Our ref: NE/2011/111405/01-L01
Your ref: N6/2010/3120/DC3
Date: 29 March 2011

Splashlands, Stanborough Road, Welwyn Garden City.

Redevelopment of site to provide a wet play area, adventure play areas, an educational play area, high ropes attraction, changing huts, education room, cafe and toilet facilities.

Project:
STANBOROUGH PARK
SPLASHLANDS
PHASE 2
Drawing Title:
PROPOSED WATER PLAY PARK
BARGE AREA, VIEWING PLATFORM,
BOUNDARY FENCE & CHANGING HUT DETAILS

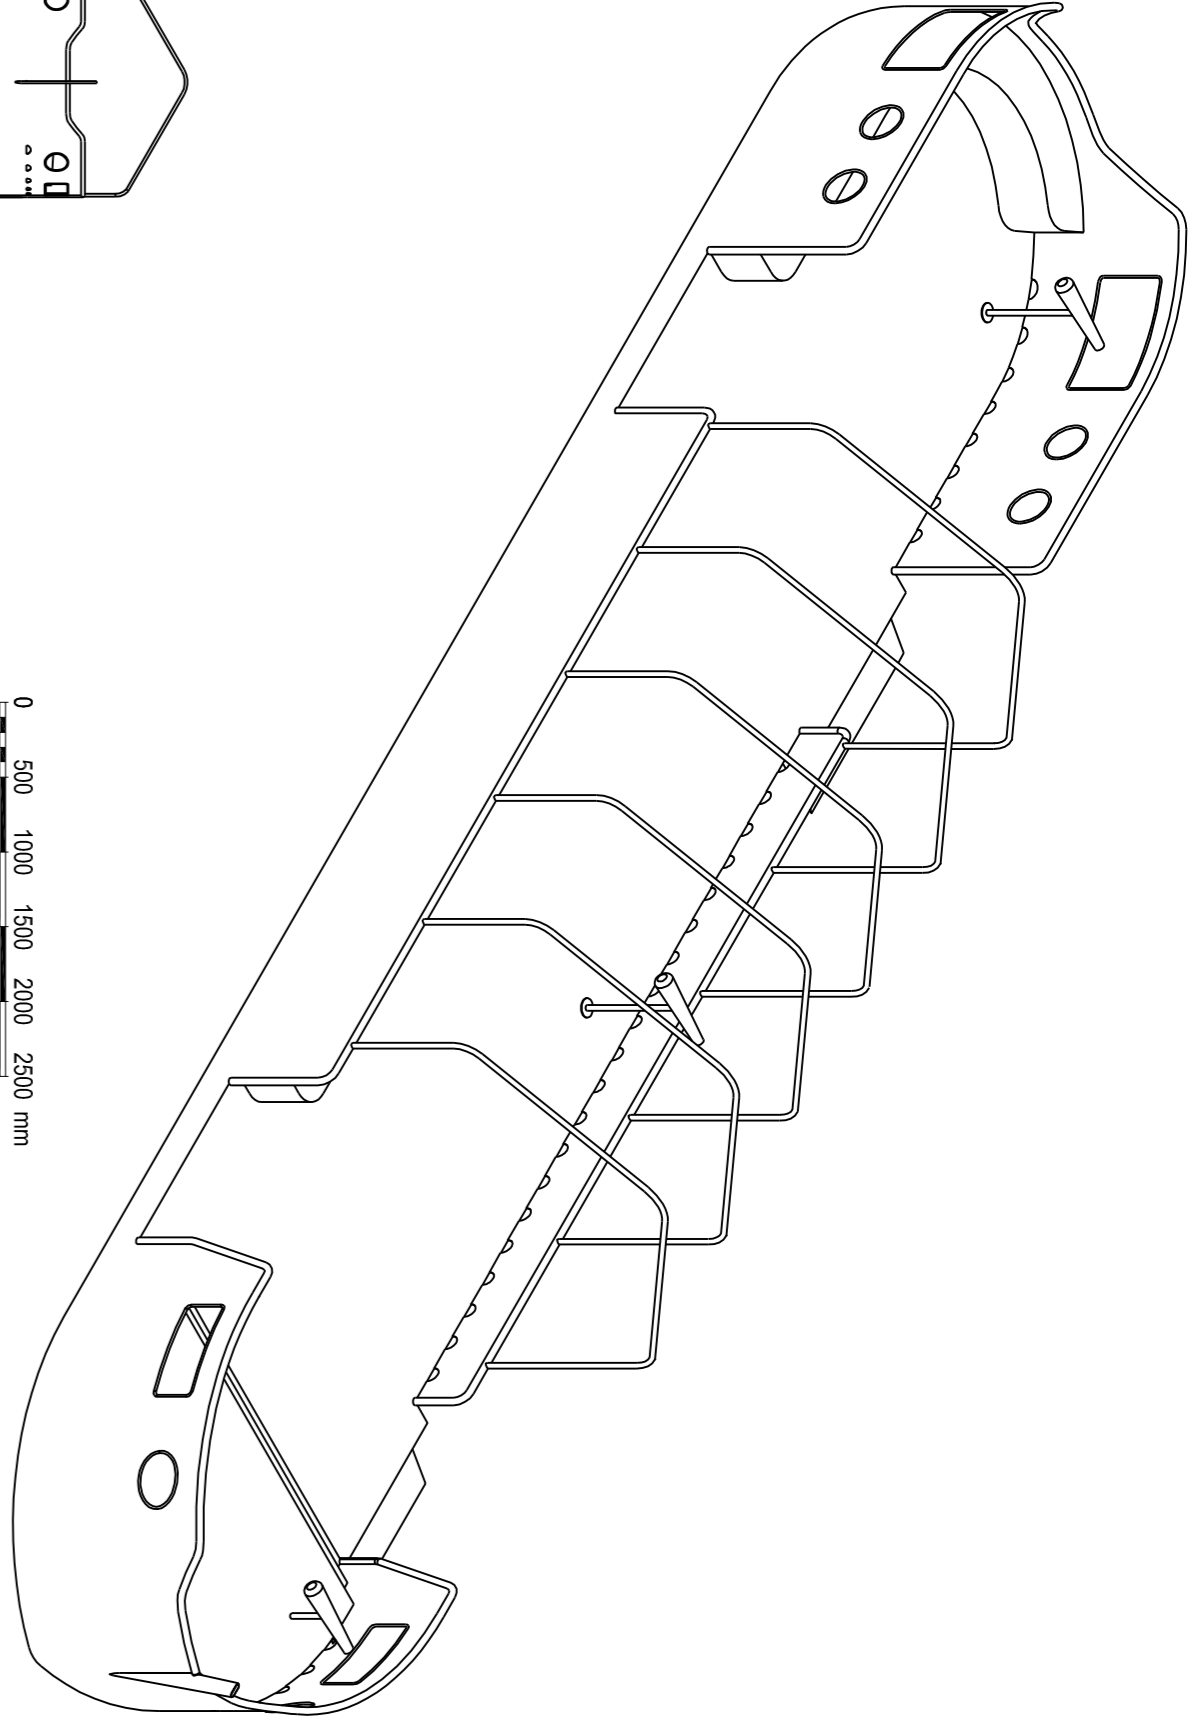
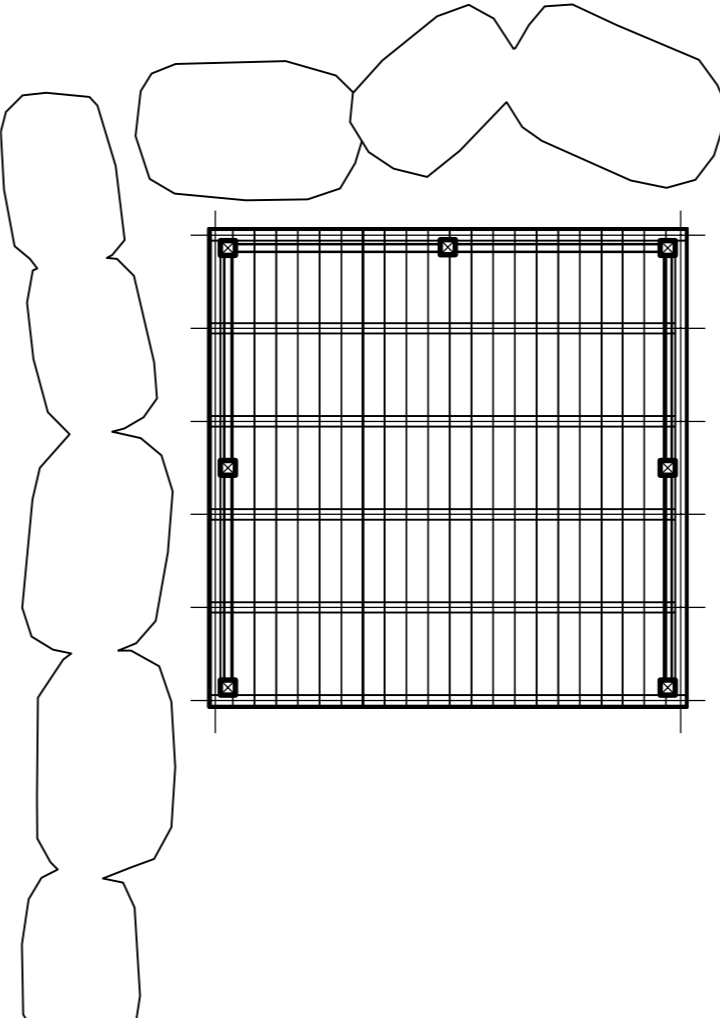
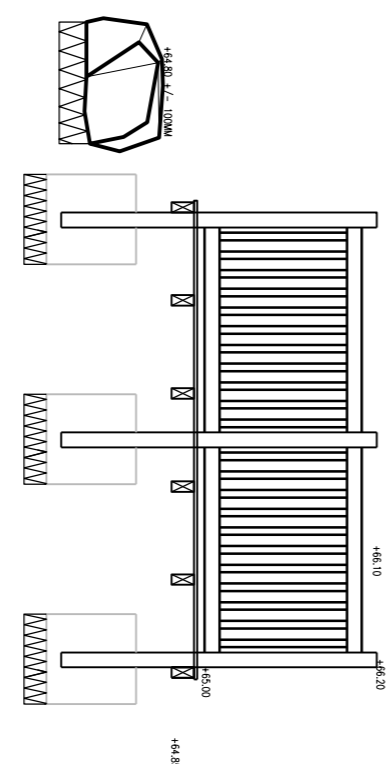
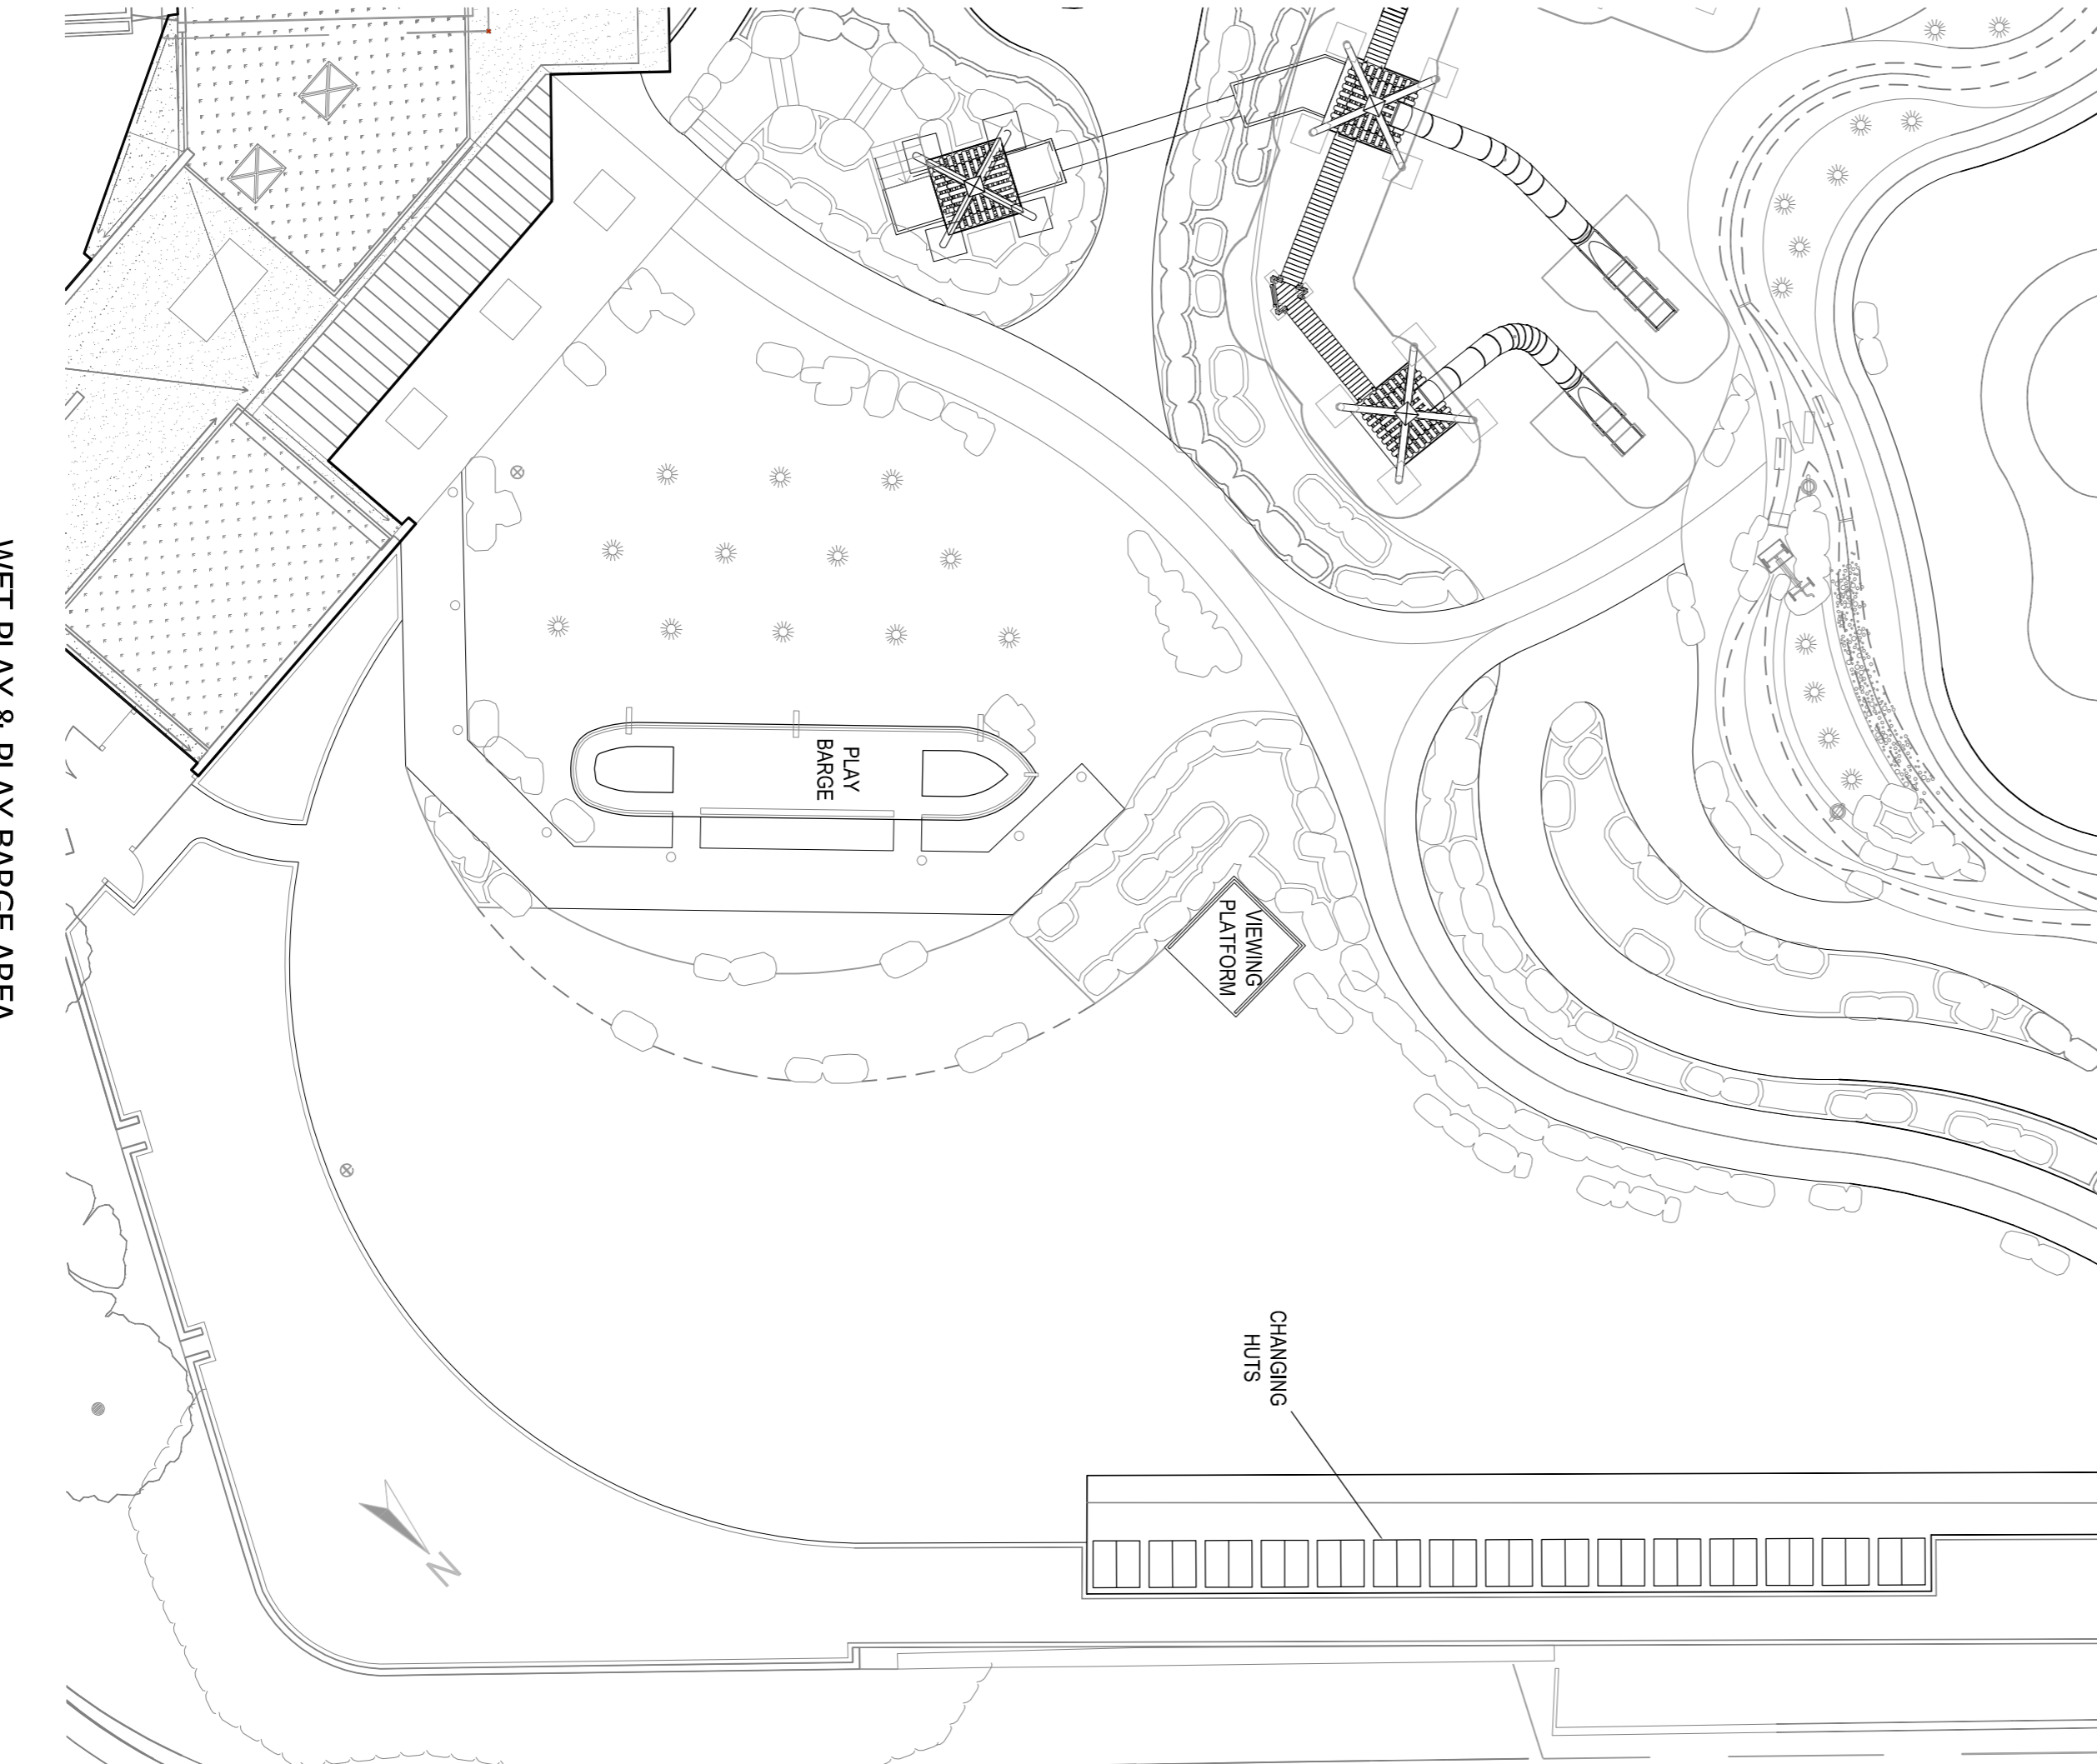
1. Provide sufficient information to demonstrate that the flood plain compensation scheme will ensure that there is no increase in flood risk as a result of this development.
2. Demonstrate that Sustainable Drainage Systems have been maximised for surface water attenuation.
3. No information has been provided about the timber viewing decks and other riverside features.

All works within 8 metres of the River Lee require Flood Defence Consent irrespective of planning permission granted. To ensure that the riverside features

are acceptable we will need to see further detail which demonstrates that there is no adverse impact upon river flows or biodiversity. Please contact Sarah Smith on 017007 632629 to discuss this further.
